Peter & Maggie Lynch
6 Gospond Road, Barnham, Bognor Regis
West Sussex, PO22 0EU

EG/87/14/NMA

Application for Non-Material Amendment

Drg. no. 1420 / 03

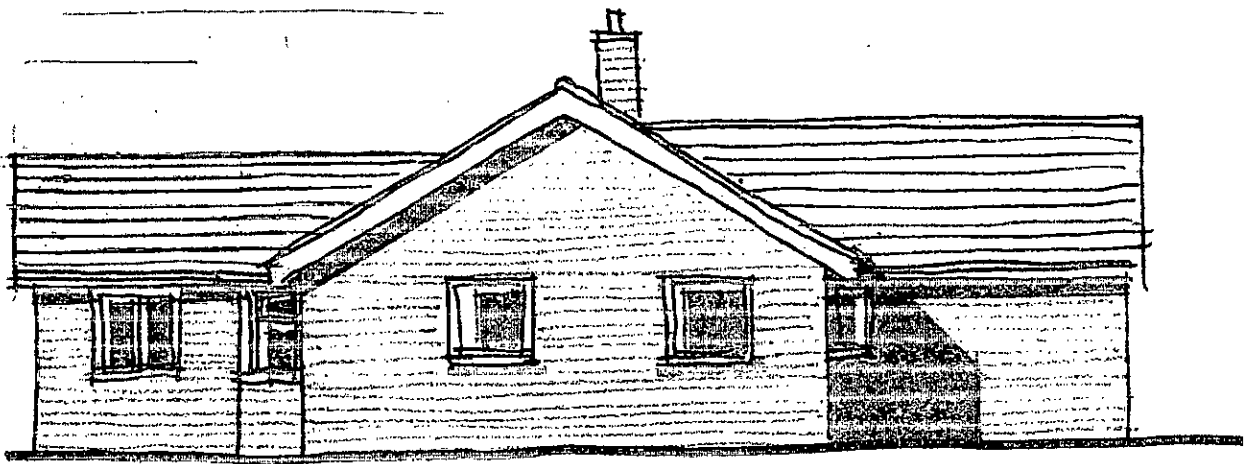
The problem of the hip roof was highlighted by the builders when they went in search of the roof tiles, strange looking Delta concrete tiles, and also after a conversation with the Building Inspector who indicated that he would prefer a Gable Roof as it would match all the other bungalows in the row.
